**CITY OF ALBUQUERQUE
PLANNING DEPARTMENT
November 10, 2015
DRB Comments**

Project #1010652

APPLICATION # 15-70399

RE: Tract 11, Ladera Business Park

SKETCH PLAT  
 OF TRACTS 11-A, 11-B AND 11-C  
 BEING A PROPOSED RE-PLAT OF TRACT 11  
 LADERA BUSINESS PARK, UNIT 1  
 NOVEMBER 2015

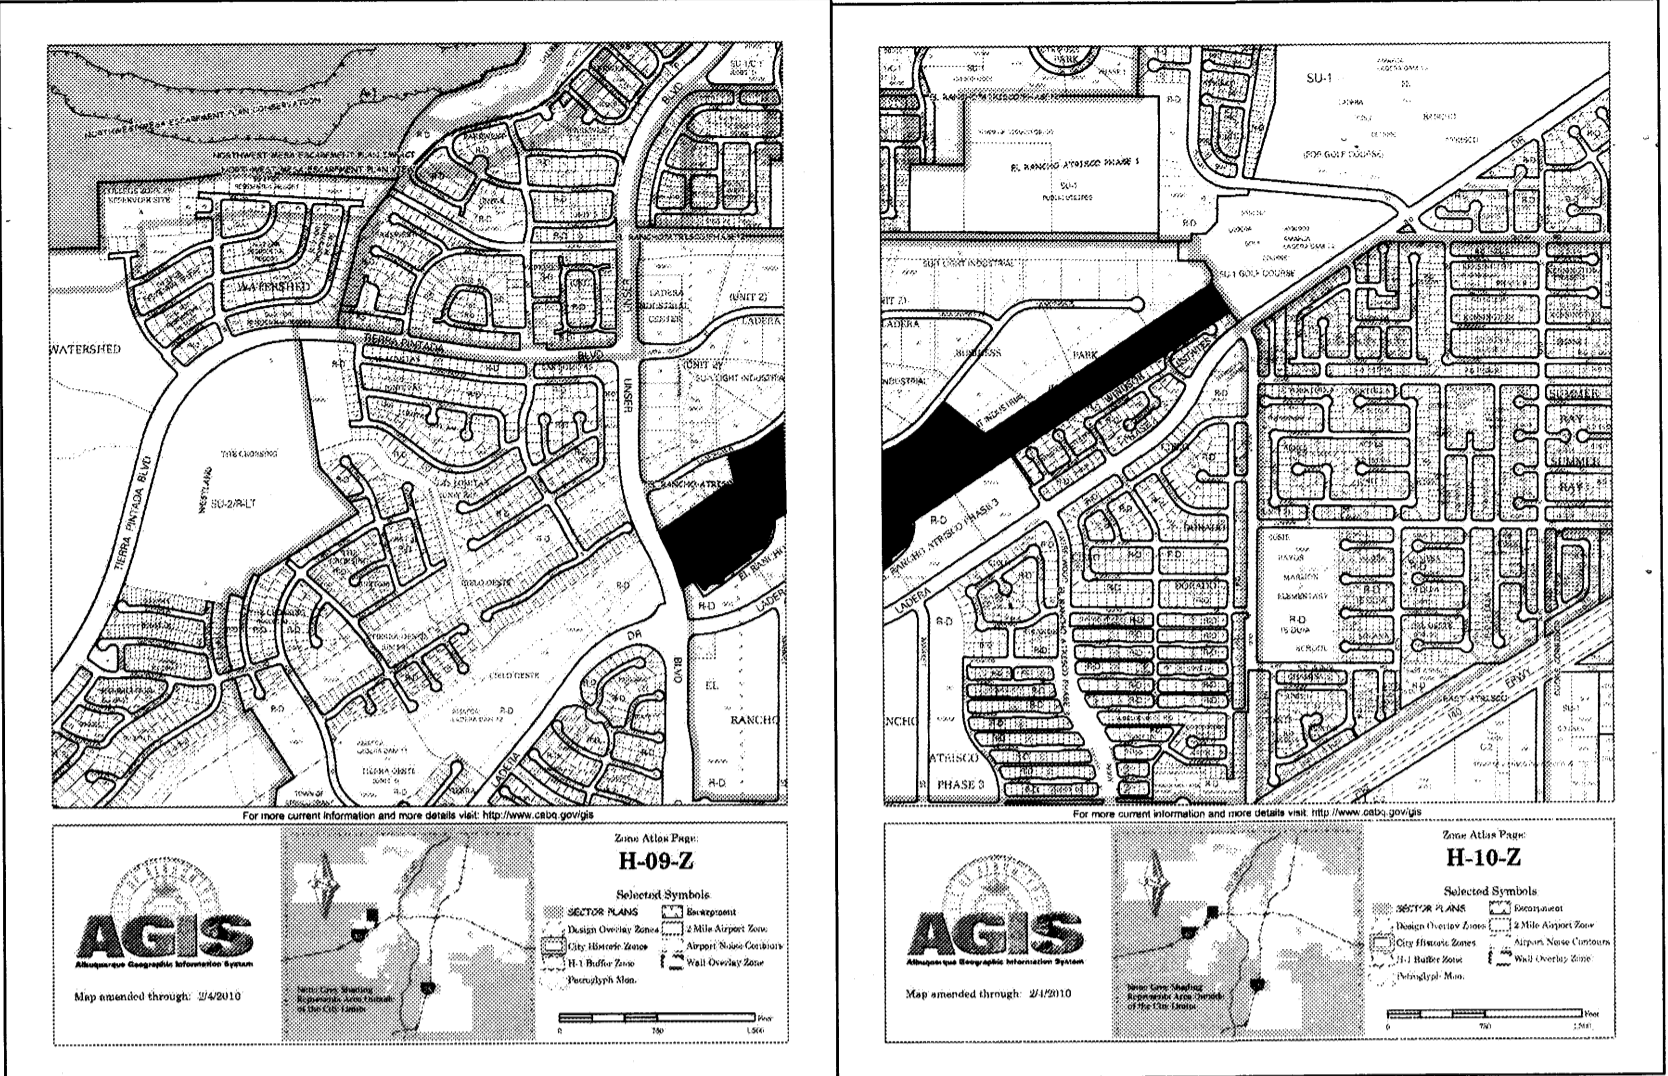
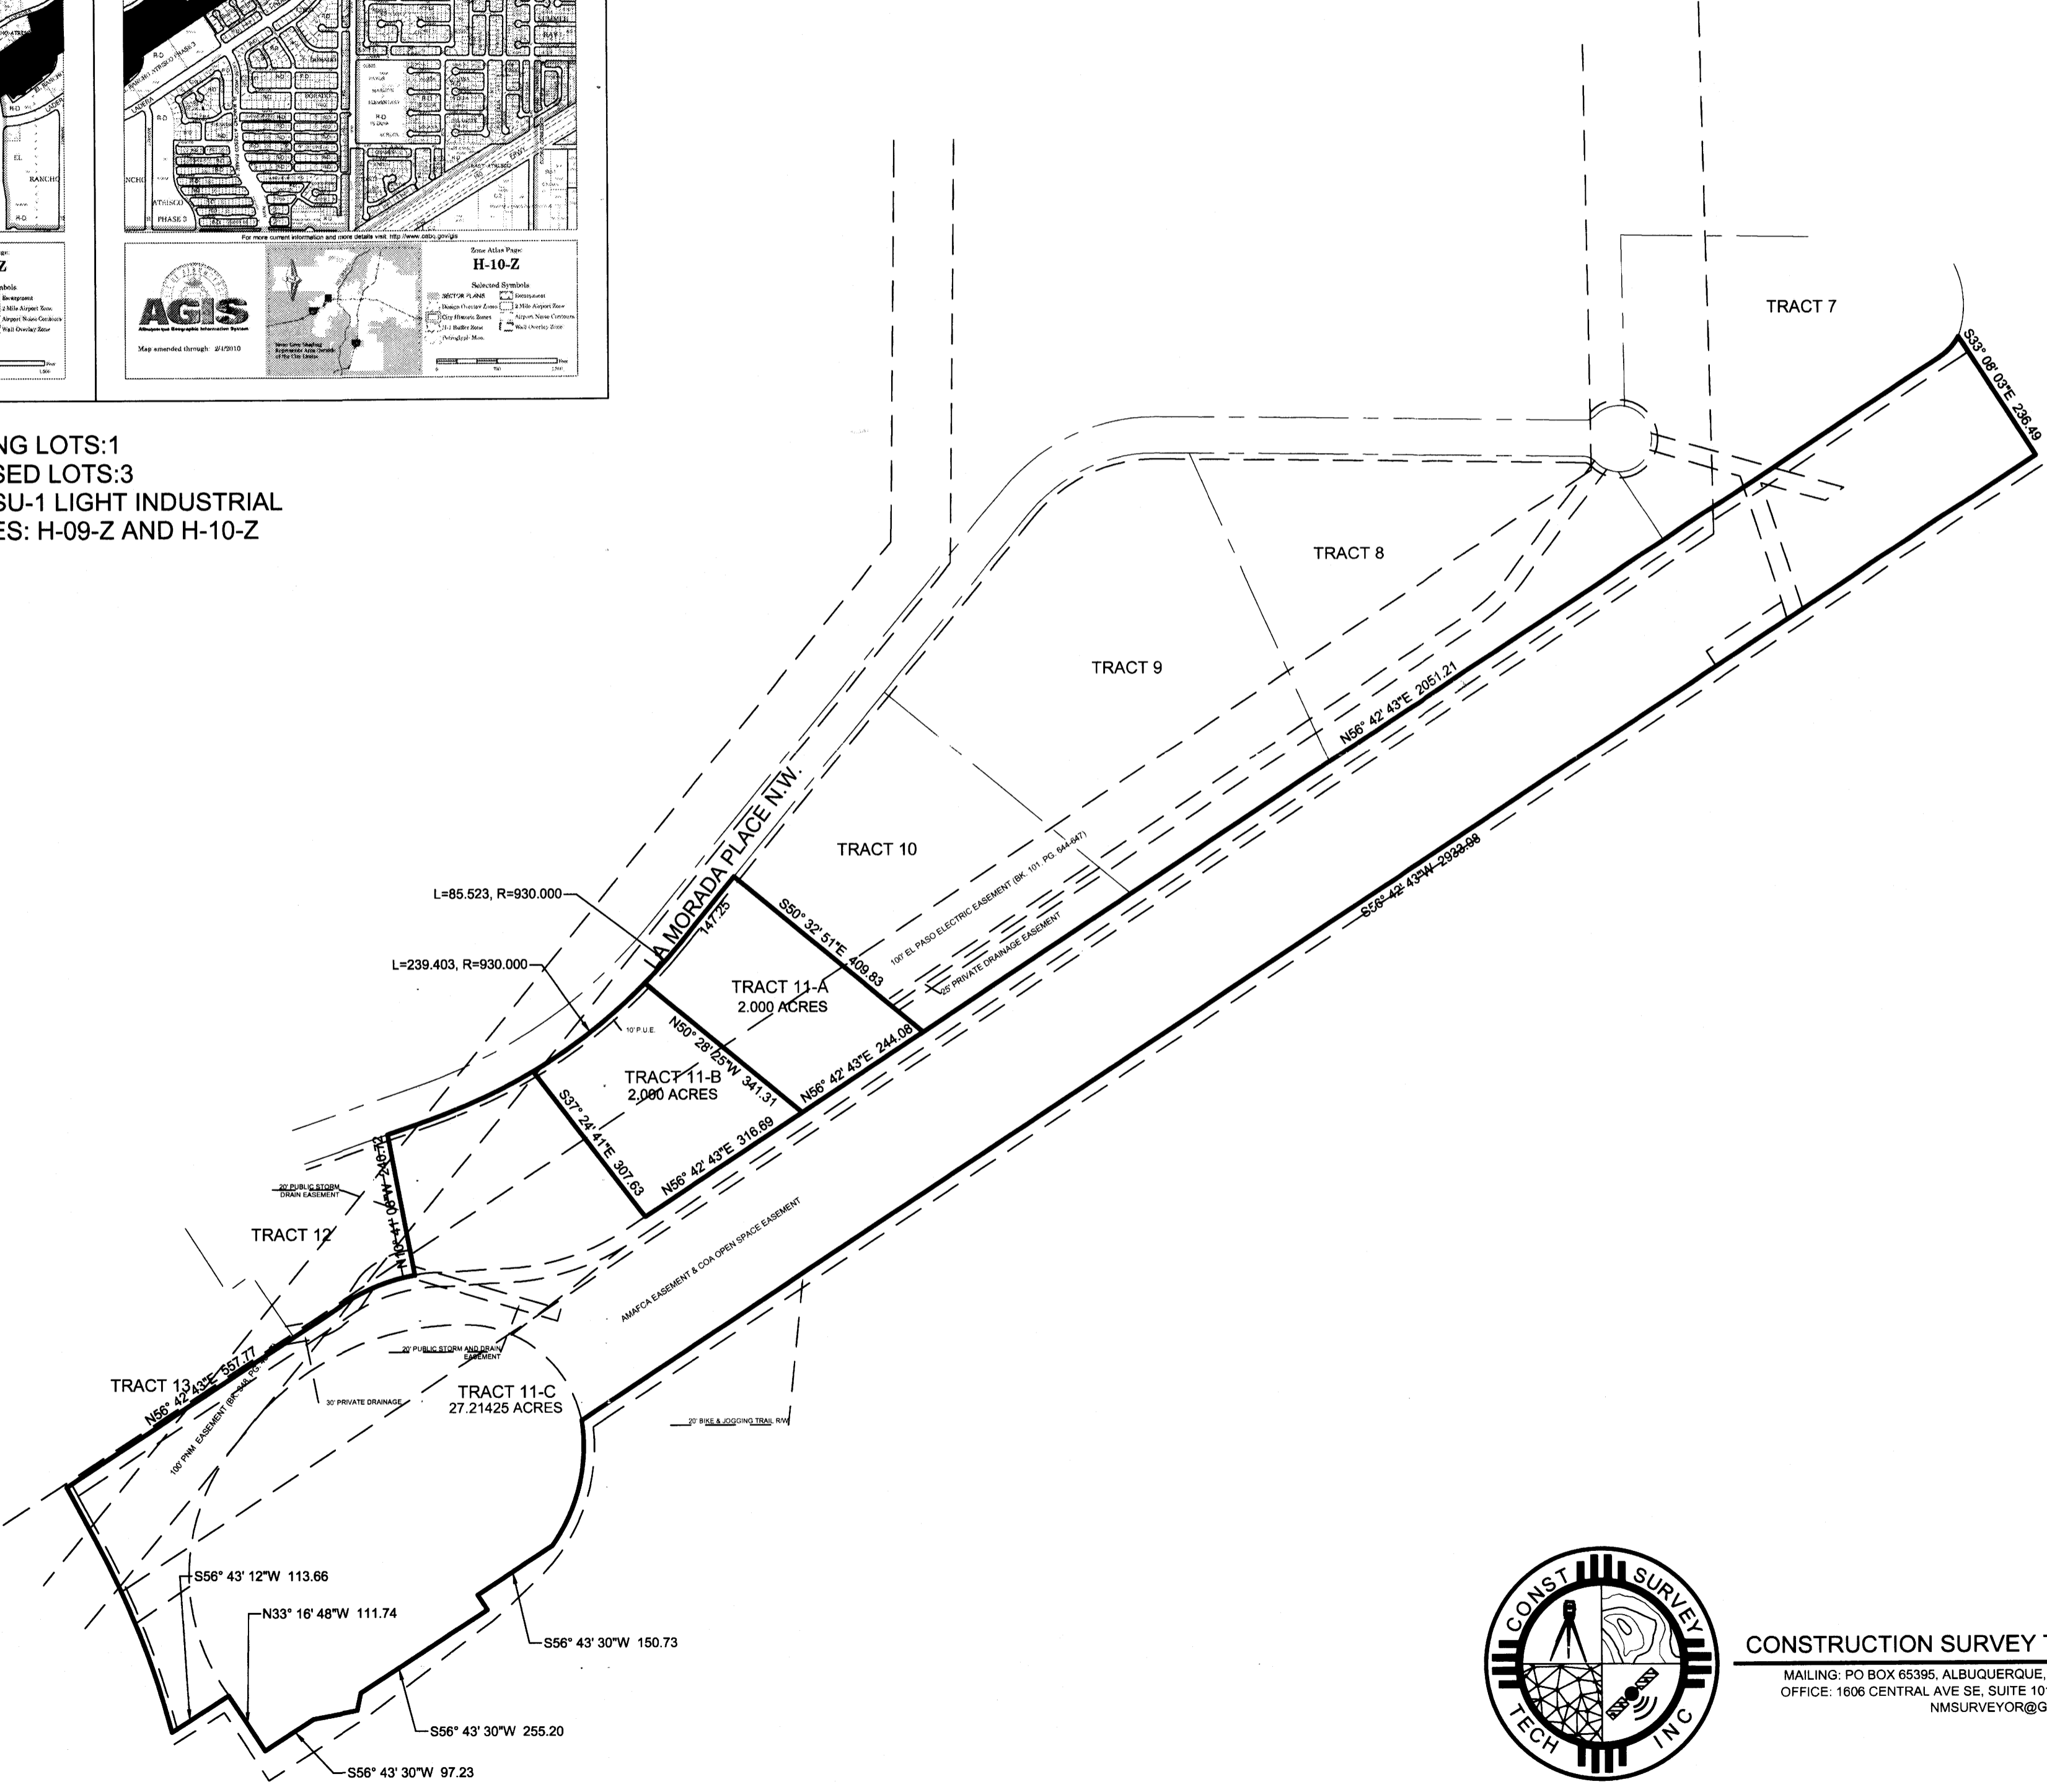
The site is an SU-1 zoned site. As a result, the plat must conform to an approved site development plan, i.e. the Ladera Business Park Master Plan must be amended to show the proposed lots.

The zone boundary needs to be identified on the final plat (without designating the categories).

Dwg: A1130FPS2-4.dwg	Drawn: STEPHEN	Checked: ALS	Sheet 2 of 8
Scale: 1"=200'	Date: 01/14/04	Job: A01130

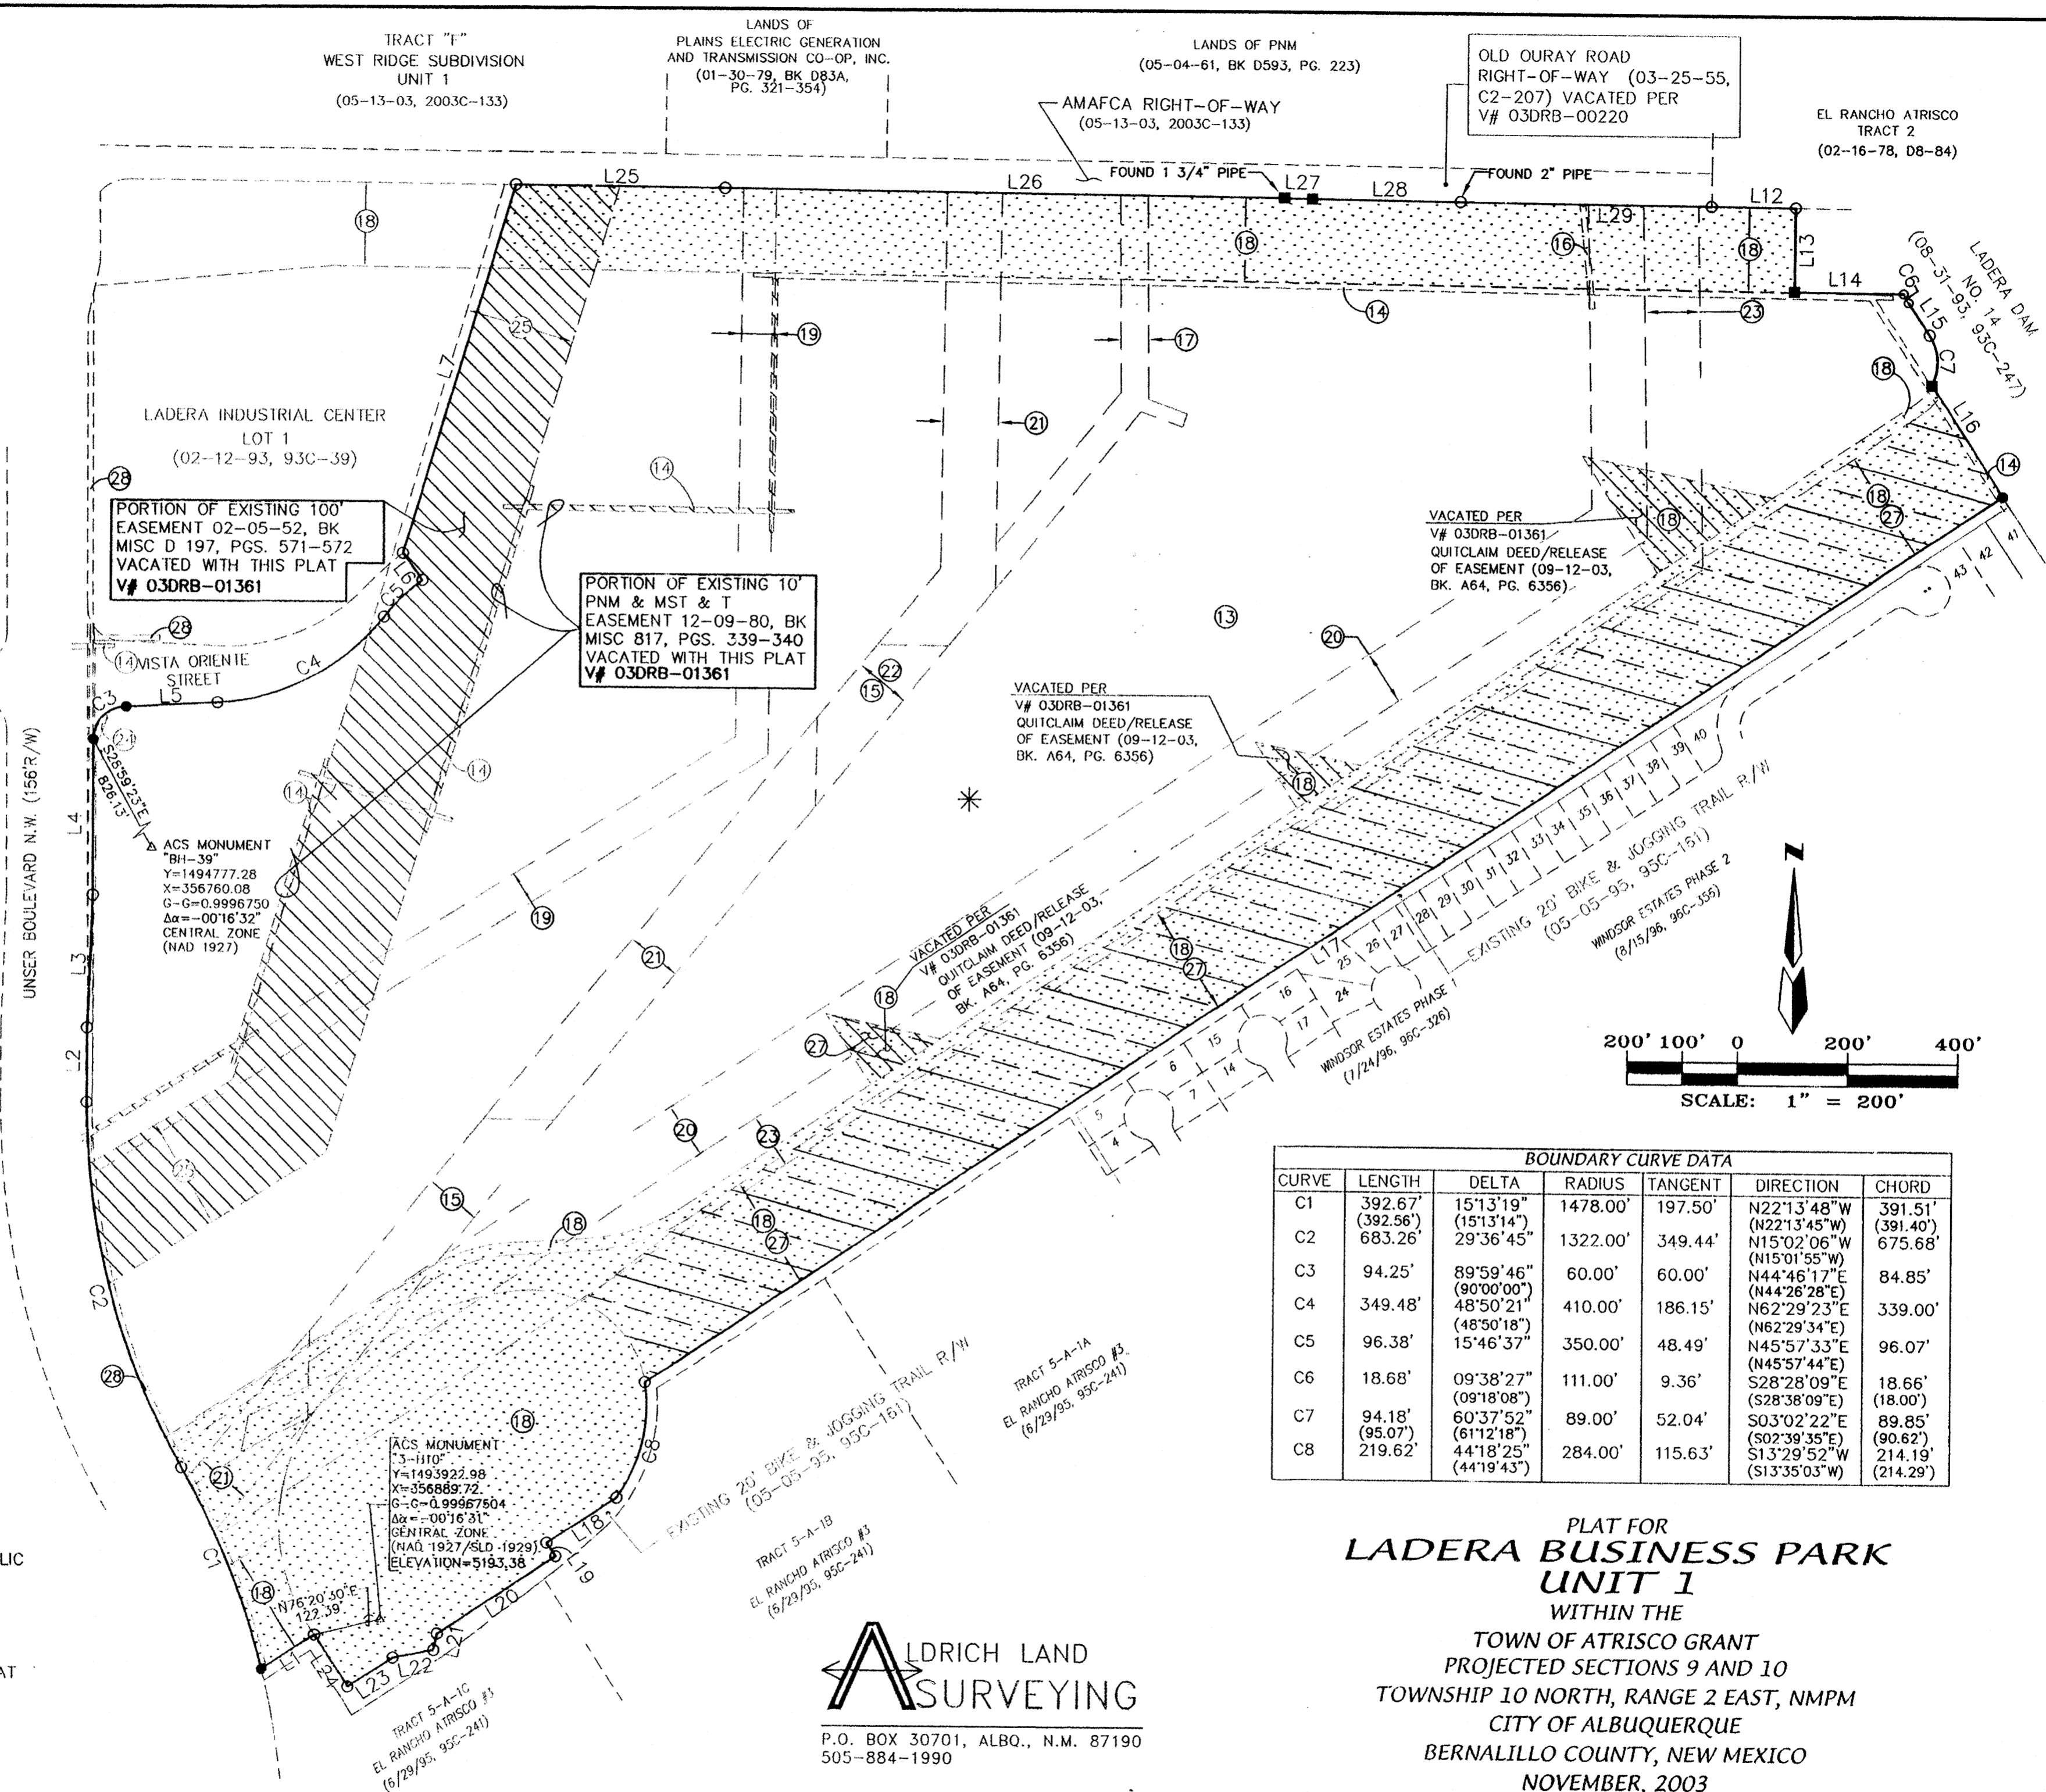
Per the 2004 plat Sheet 2 of 8, Tract B was to have been dedicated to the City, yet AGIS/ County Assessor layer indicates it is still owned by the applicants.
